| Urban Design Observations | | | Officer: | Stephen Kilmartin |
| Description: | Land off Waddington Road, Clitheroe | | |  Ribble Valley Borough Council www.ribblevalley.gov.uk |
| Application Ref: | 2018/0181 | Case Officer: | S.K | |
| Response Ref: | 2018/0181/UD/05 | Issue Date: | 14/01/18 | |

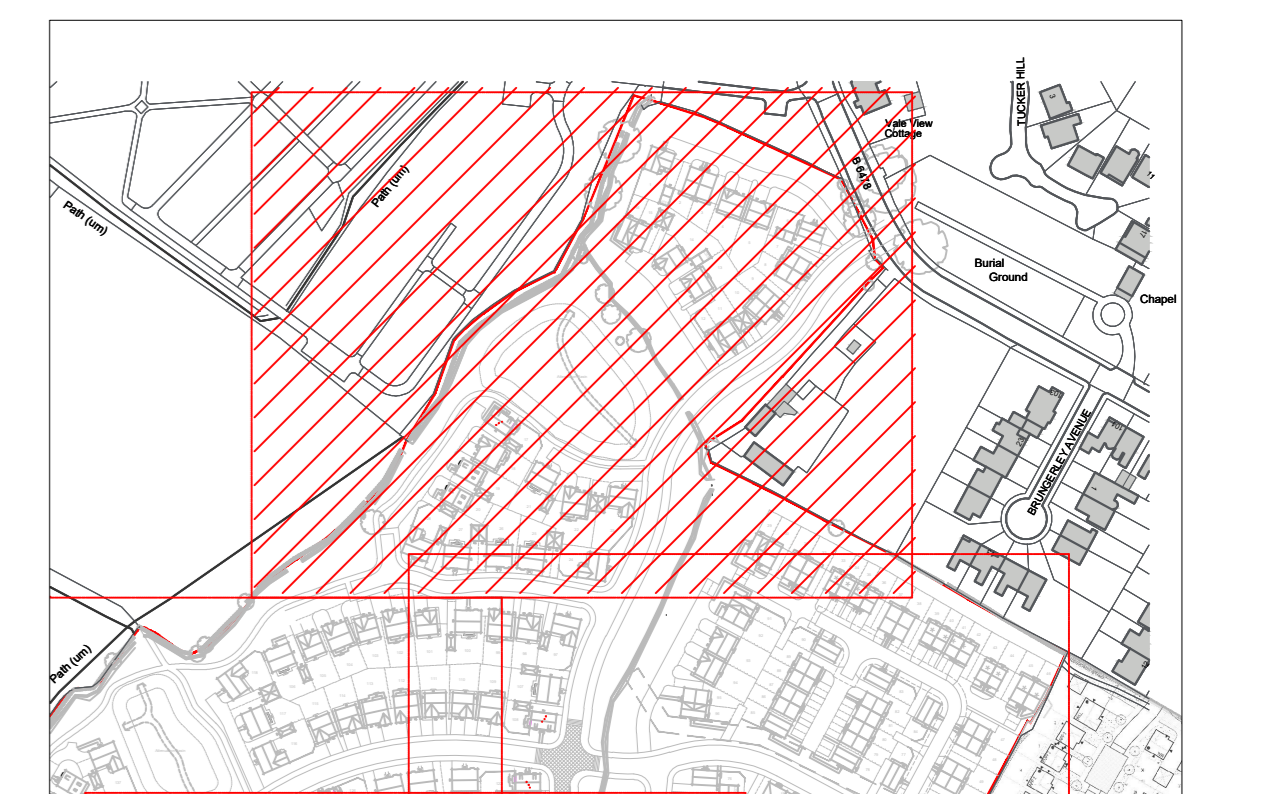
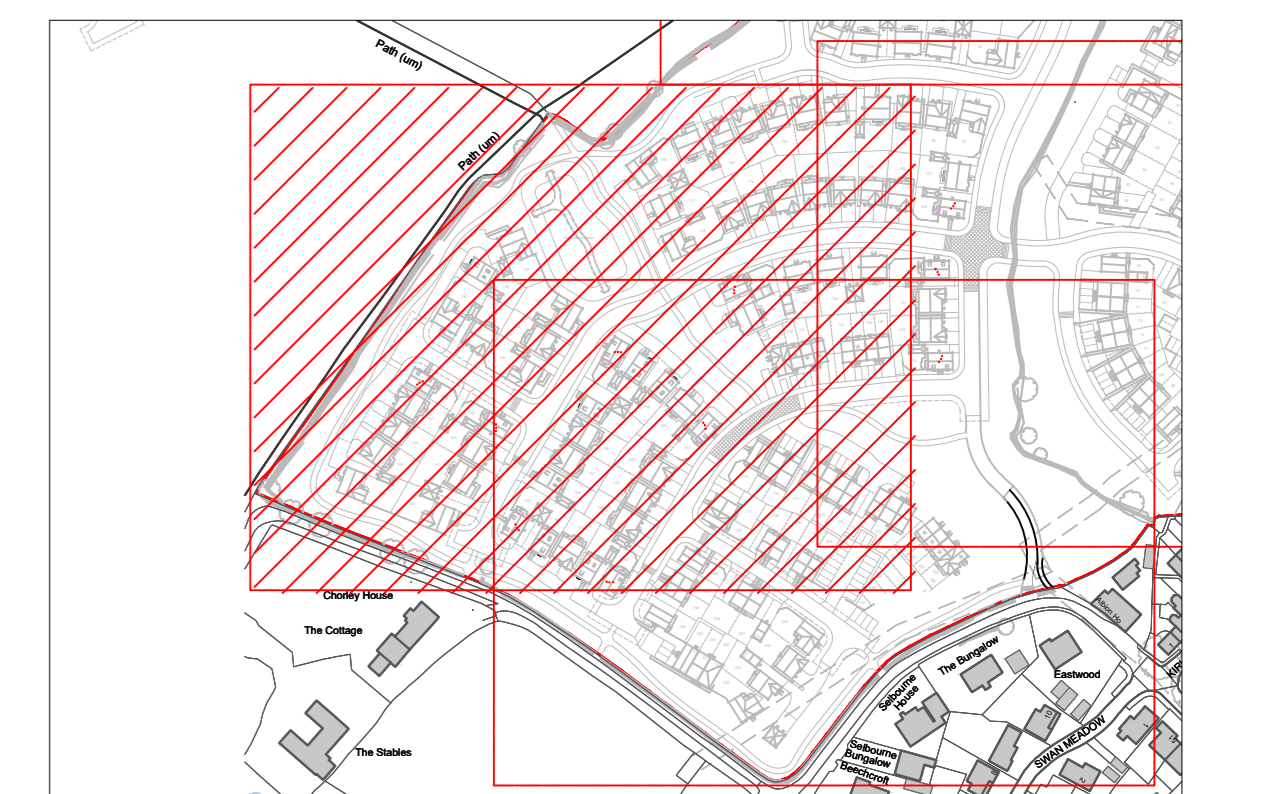
- 3.1** The proposed landscaping details fail to show or convey on-plot landscaping (plot frontages) or landscaping within the public realm within the main body of the housing development.
